Planning Application Ref: A/142/17/PL

Location: Land at Barn Farm, Dappers Lane, Angmering

Description of works: Change of use of land from storage (B8 Storage or Distribution) to a car sales yard (Sui Generis).

Comments on Application:

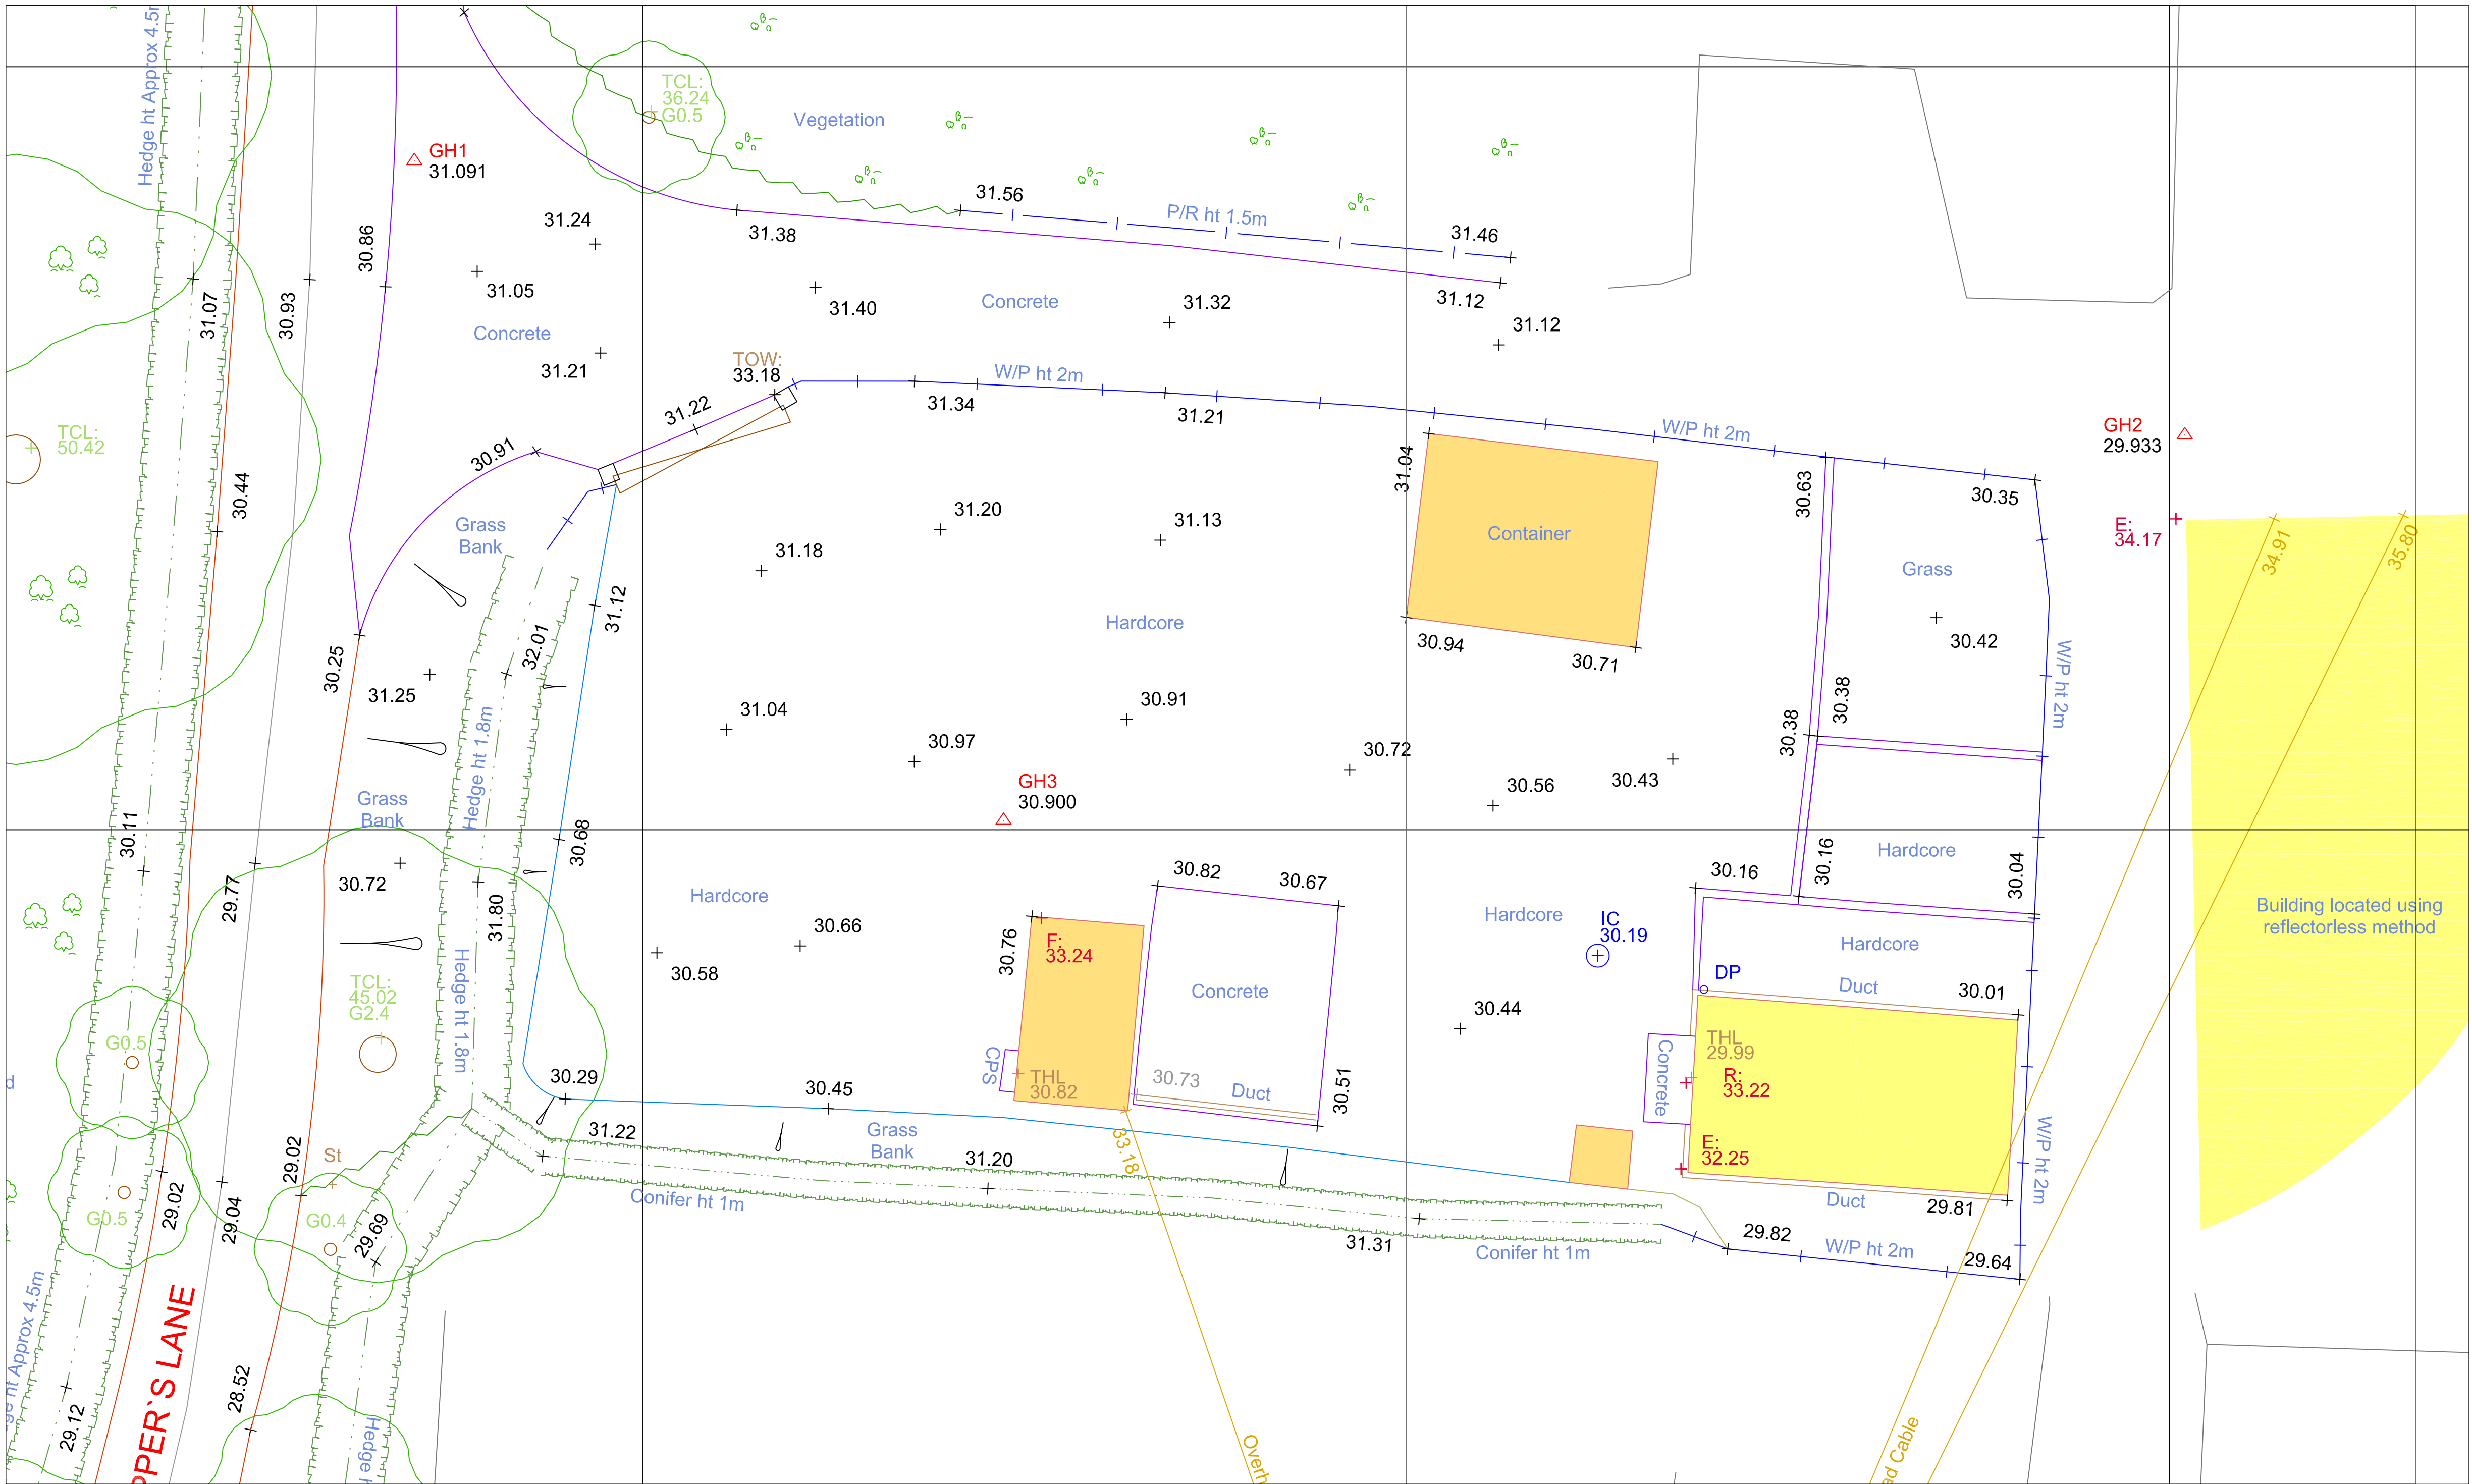
- Following significant loss of established roadside trees at the site since 2014, there remains only one tree of value that is implicated by the proposed site development; a mature roadside oak (T1). It would easily qualify as a Category B tree using the BS5837 method when considering suitability for retention. This tree is showing signs of physiological distress, most likely attributable to the change in soil level imposed by the recent and historic formation of roadside bunds, introduction of new surface materials and driveway construction at the property adjoining to the south. All of this disturbance has occurred within the Root Protection Area (RPA) of T1. The tree remains viable for long-term retention and has a good chance of full recovery if further interference above and below ground is avoided.

- The LD Statement makes reference to a previous planning permission (A/113/16/PL). Site Block Plan, dwg.P1342 01 clearly defines a storage area for building materials reinforced by Condition 4 attached to the decision notice. This is outside of the RPA of T1. The proposed location of containers (if still an intention) is also shown to be outside the RPA, which is reassuring but not binding at this stage.

- I recommend **APPROVAL** for this application in its current form, subject to the following conditions being applied and the making of a Tree Preservation Order (TEMPO form and GIS plan attached):
 - No building materials or supplies to be deposited within the Root Protection Area (calculated as being 7.2m from the stem base) of T1.
 - No siting of containers or other structures within the Root Protection Area of T1.
 - The installation of post and rail fencing within the RPA of T1 must be undertaken with care so as to avoid damage to tree roots. Only hand-digging is permitted, and of sufficient depth and width as necessary to accommodate below ground fixing of posts. Leachate from curing concrete can be toxic to tree roots therefore all pits are to be lined with impervious membrane before pouring concrete.
